WEST SUSSEX COUNTY COUNCIL CONSULTATION

TO:	Arun District Council FAO: Anita Gardner
FROM:	WSCC - Highways Authority
DATE:	21 December 2020
LOCATION:	Woodies Newsagents, The Square, Angmering, BN16 4AE
SUBJECT:	A/189/20/PL Provision of permanent outside seating & awning. This application may affect the setting of a listed building, affects the character & appearance of the Angmering Conservation Area & is in CIL Zone 2 (Zero Rated) as other development.
DATE OF SITE VISIT:	N/A
RECOMMENDATION:	Advice
S106 CONTRIBUTION TOTAL:	N/A

Block Plan reference Outside Seating	
Client	S Beituni
Site Address	The Resourceful Squirrel Red Lion Building / formerly Woodies Newsagent High Street Angmering BN16 4AE
Printed	As Shown on A4
Date	11/11/20
Drawing Number	SB outside seating

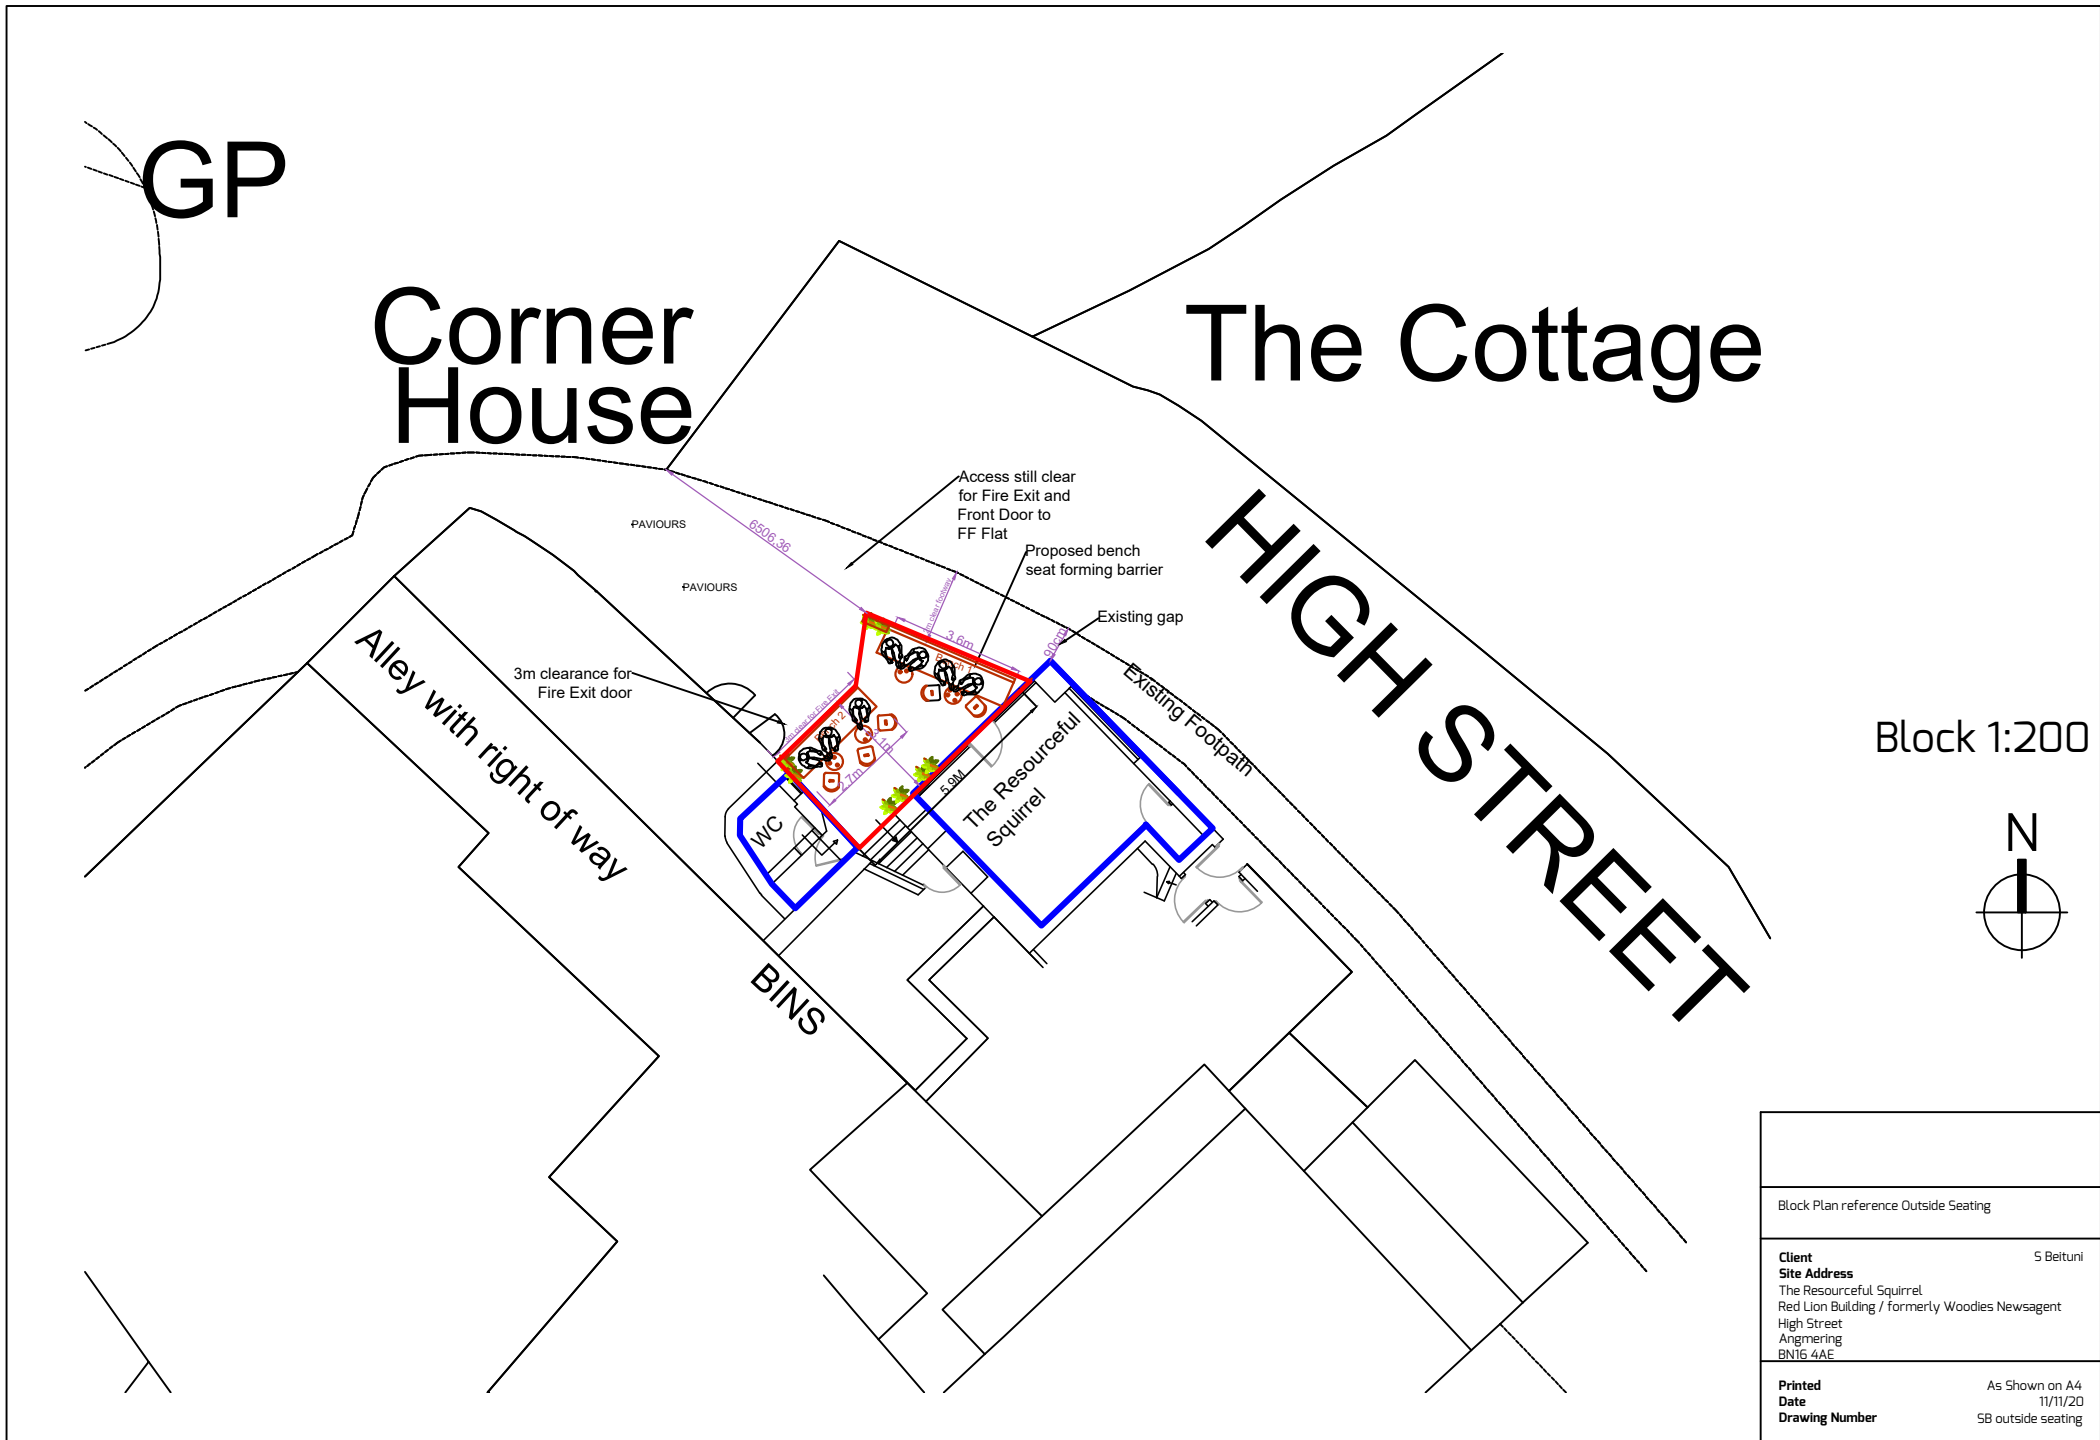
The proposed seating area appears acceptable in highways terms. The seating area will leave sufficient space as to not obstruct pedestrians using the footway in this location. The seating area will be situated within publicly maintained highway; therefore, the items placed within the public highway are not to be permanently fixed and are to be removable. This is to permit the maintenance of the public highway and to ensure that a permanent obstruction does not result.

The items placed within the public highway are not to be permanently fixed and are to be removable. This is to permit the maintenance of the public highway and to ensure that a permanent obstruction does not result.
